NORWICH TO TILBURY

EN020027

Comments on Submissions received at Deadline 1

Suffolk County Council [REDACTED]

Drawing Number:
 10059280-ARC-ELS-ZZ-DR-ZZ-00300

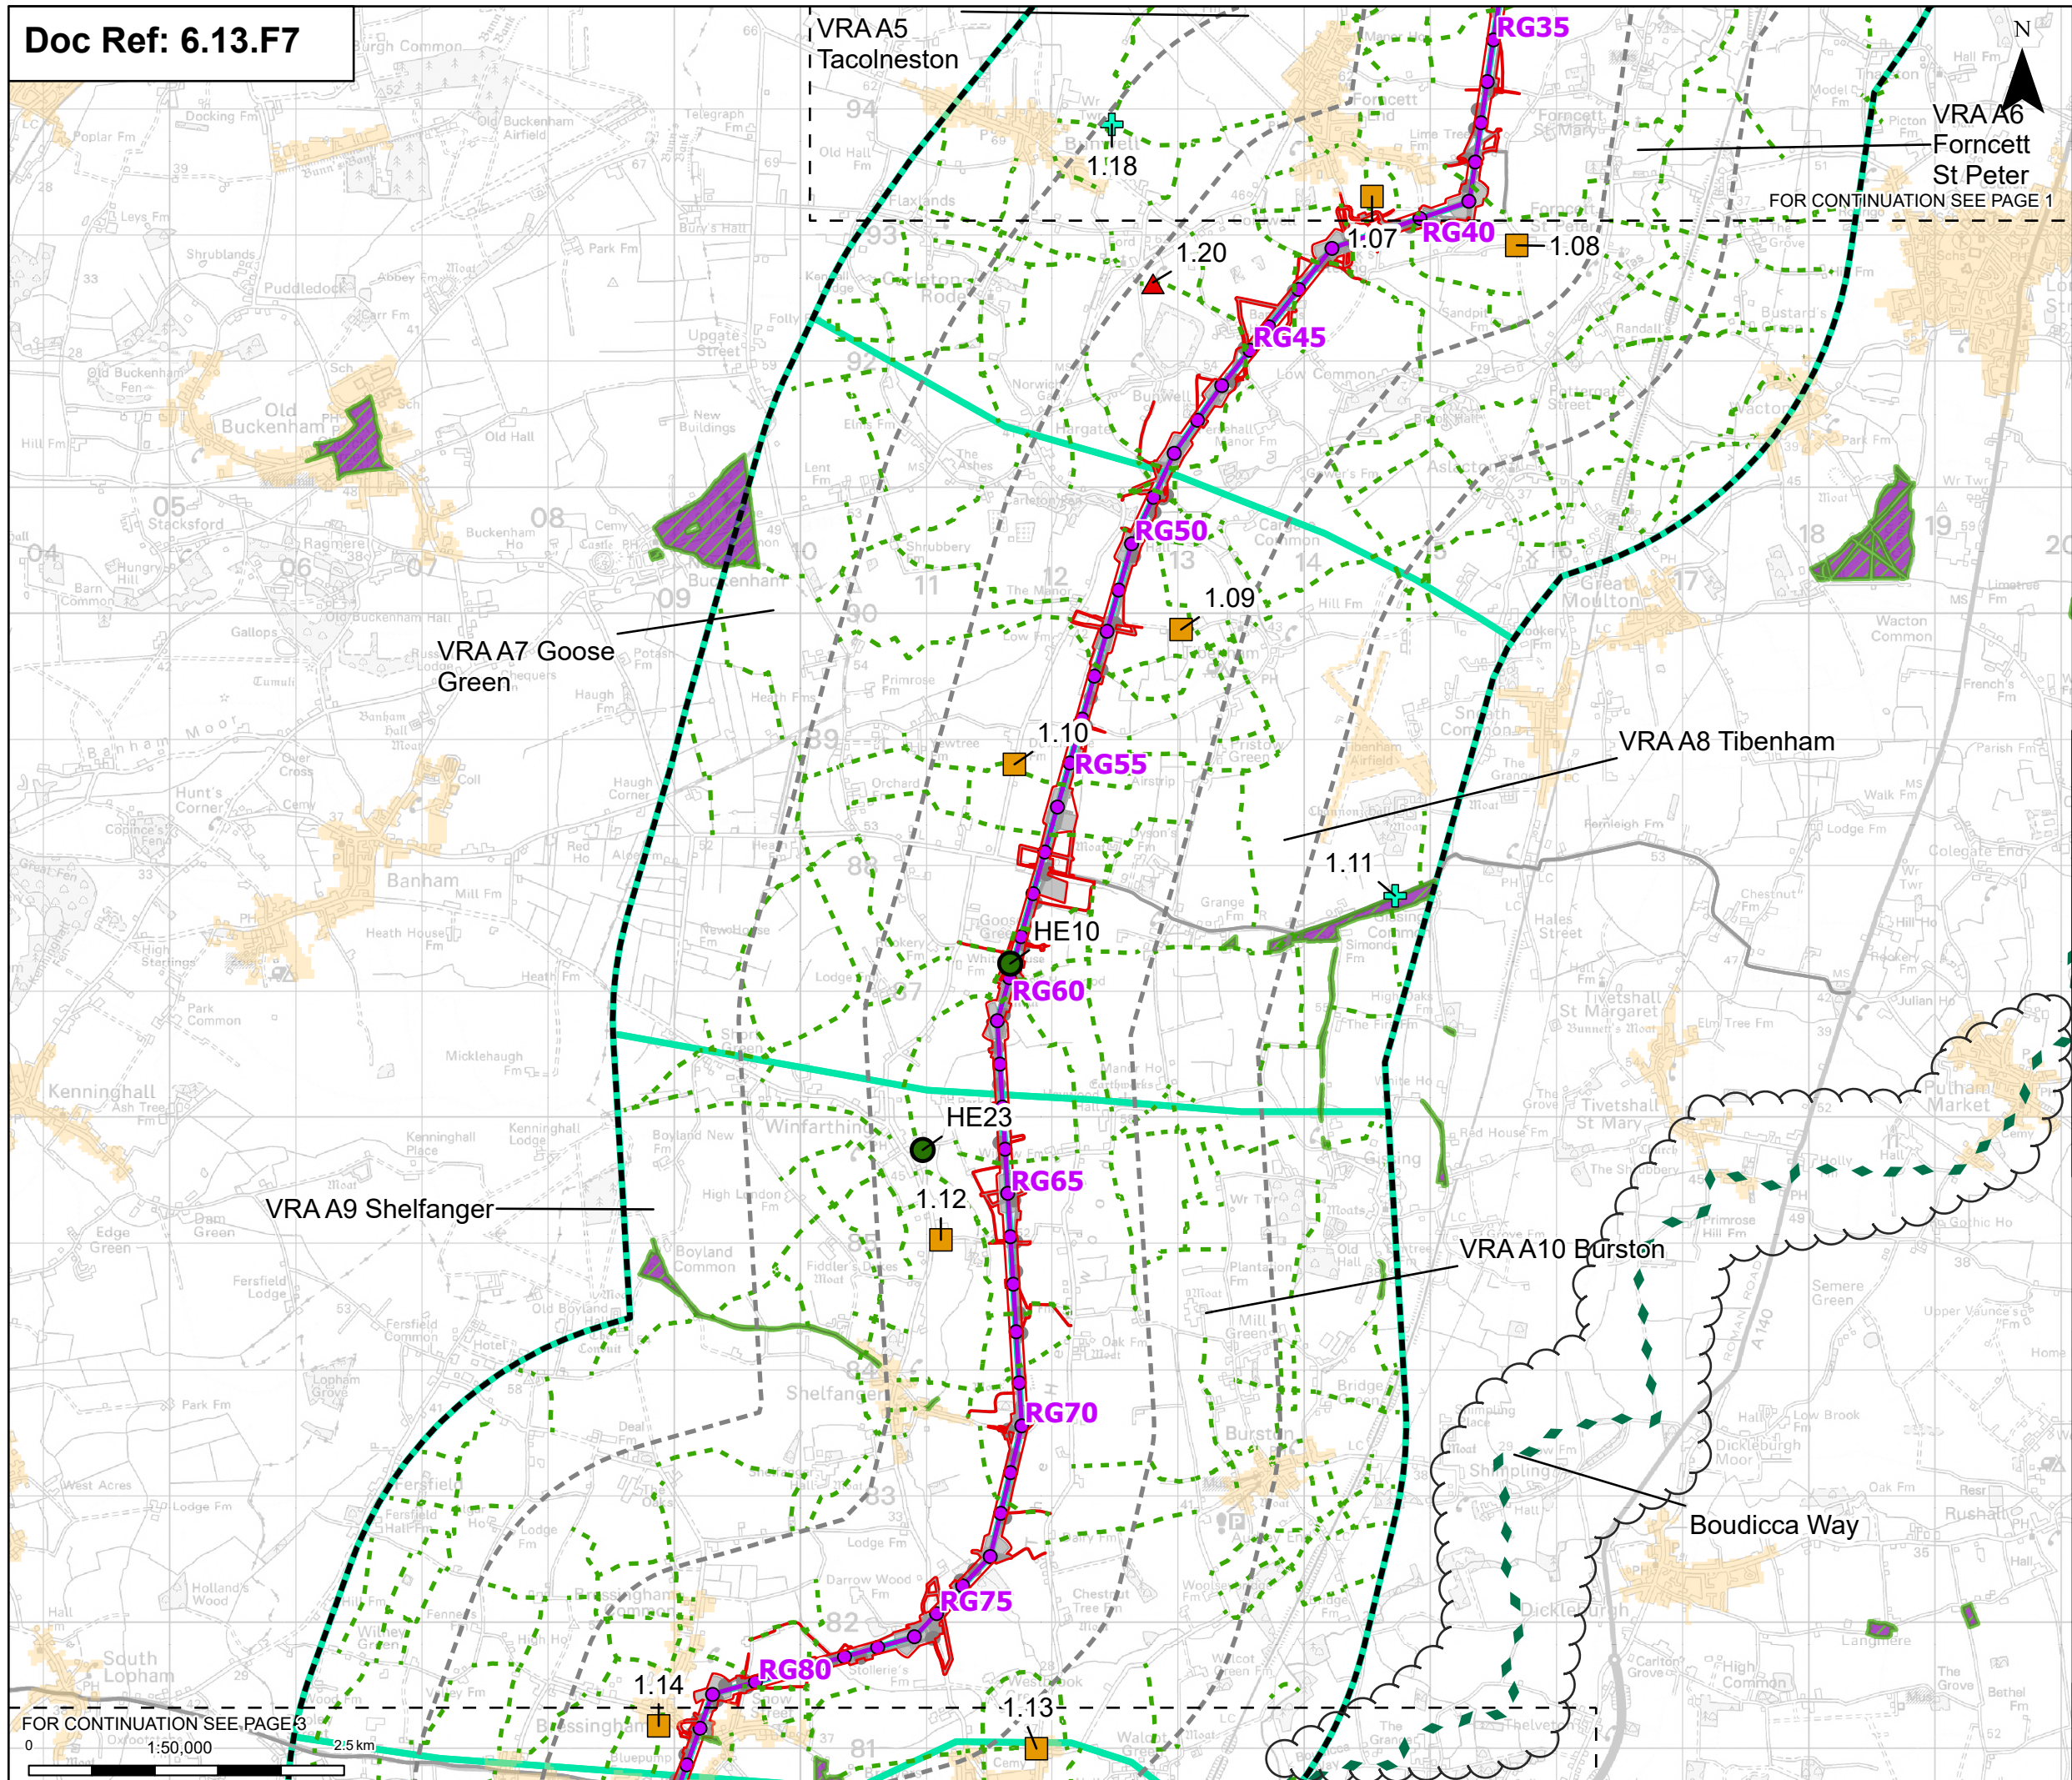
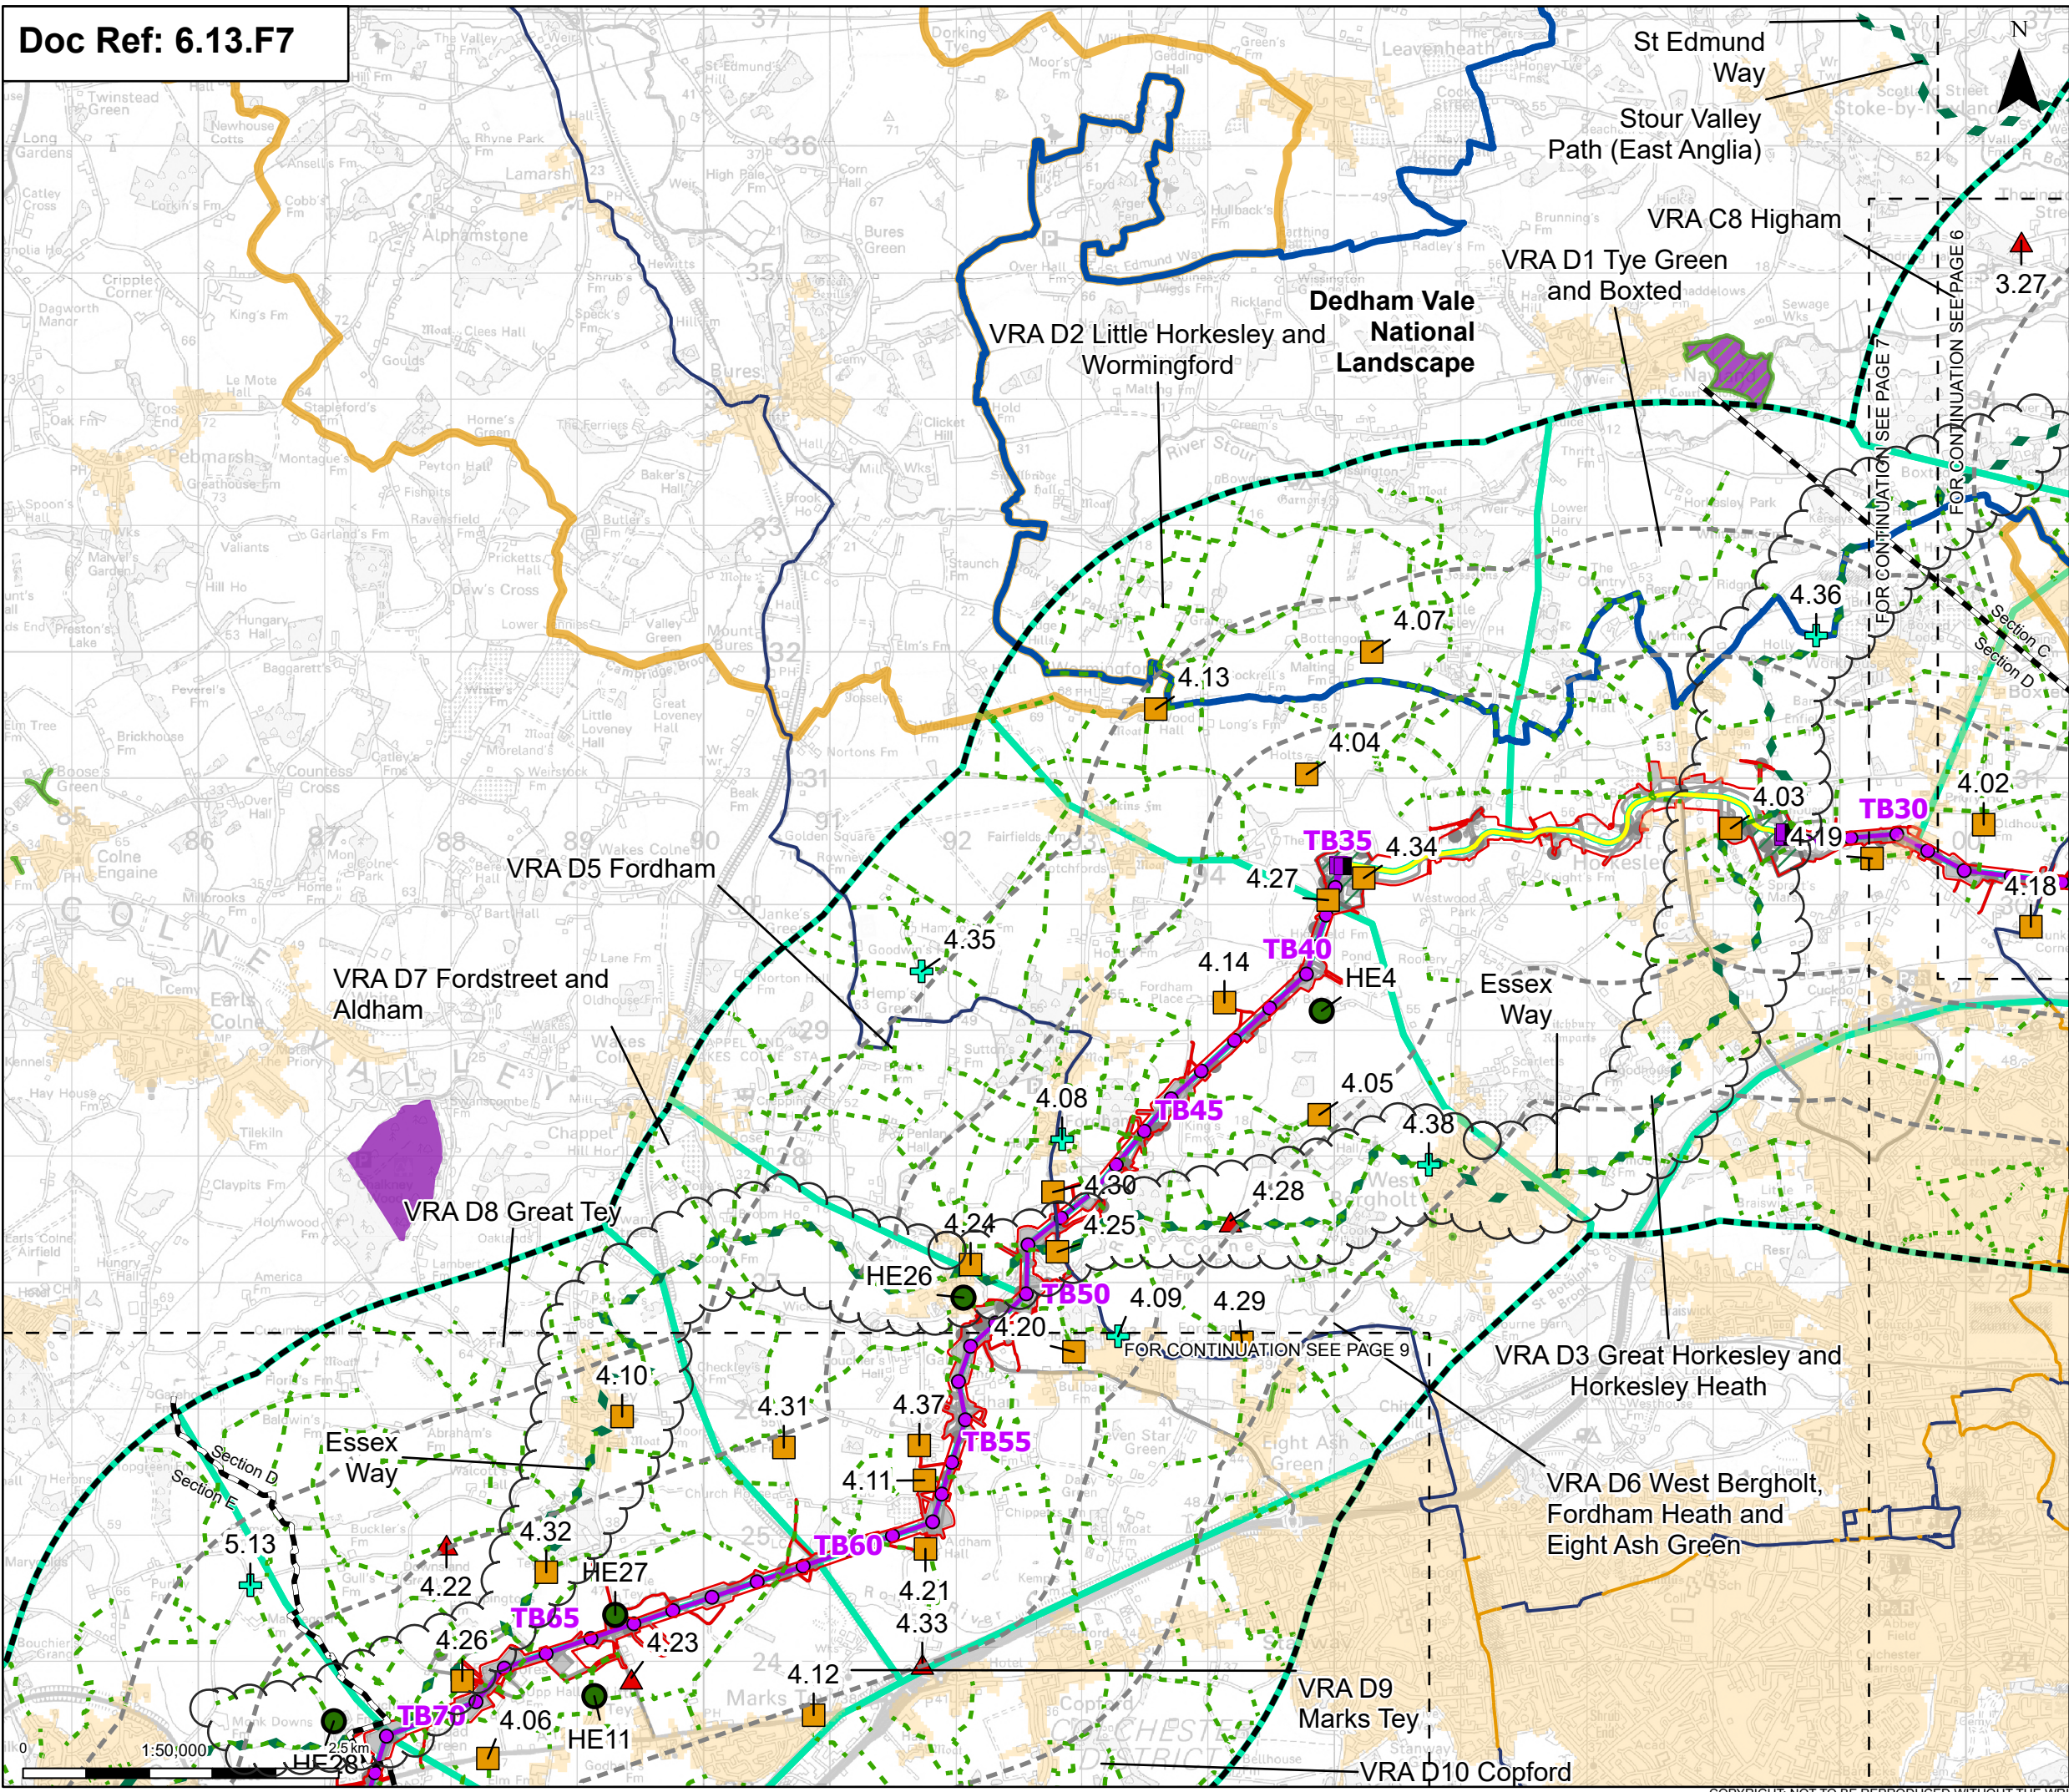
3.2	Errata	<p>Table 1.1 (6.13.F7) Environmental Statement Figure 13.7: Visual Receptors and Viewpoints</p>	<p>SCC would welcome, if the Applicant was to confirm that this was the only change between the two versions. Alternatively, if other additional changes have been made, SCC considers that the</p>	<p>[APP-243] [REP1-071]</p>

<p><i>“Incorrect revision uploaded in error with application - long distance footpaths were not included on the Figure.”</i></p> <p><i>“Figure 13.7: Visual Receptors and Viewpoints [APP-243] has been updated and is replaced by Figure 13.7: Visual Receptors and Viewpoints (Rev B) in Appendix A of this Errata.”</i></p>	<p>Applicant should clearly list what they are and on which sheets of the figure they can be found.</p> <p>No explanation is given as to the changes that have been made in Revision B versus Revision A [APP-243]. A page at the beginning of the document, that identifies the changes made, would have been helpful for any reviewer of the documents.</p> <p>SCC would consider it helpful if the Case Team were to update the Examination Library to include a note at [APP-243] to say that Figure 13.7 is superseded by [REP1-066].</p>	
--	--	--	--	--
